## City of Portland, Me.

Date 10/3/01  
 Permit # 01-5017  
 CBL# 224 A019

LOCATION: 336 CAPISIC ST METER MAKE & # \_\_\_\_\_  
 CMP ACCOUNT # \_\_\_\_\_ OWNER Kim Krummell  
 TENANT \_\_\_\_\_ PHONE # 773-3536

A3

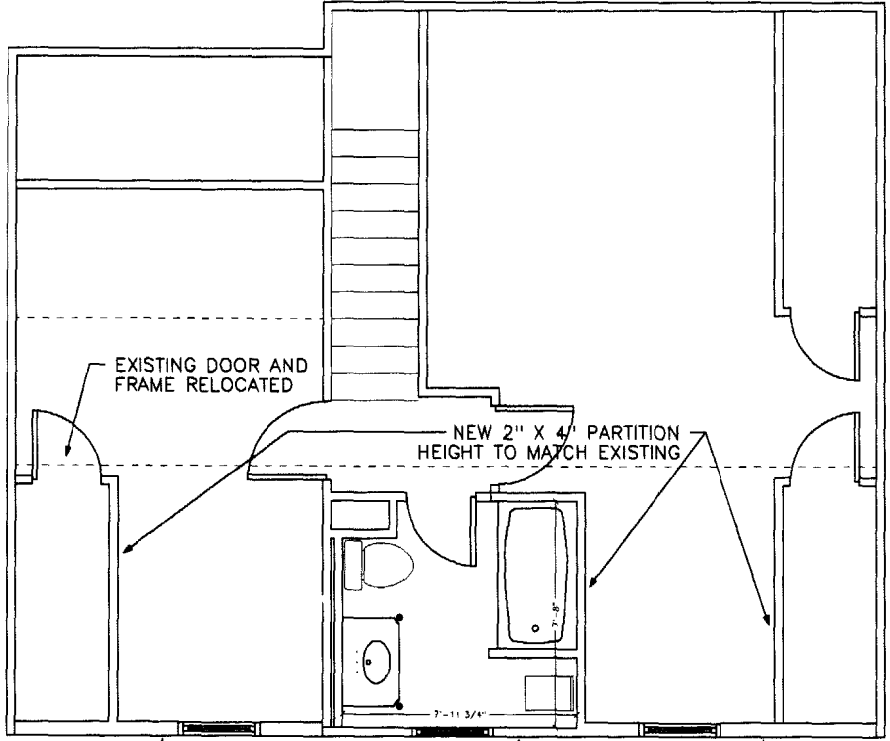
DATE	TIME	CONTACT	NARRATIVE	INITIALS
9/24/01	1:20 PM		Called and left message regarding size of rafters. - M.	
	2:00		Spoke w/owner and they will increase size of rafters - smoke's already in and will have egress windows.
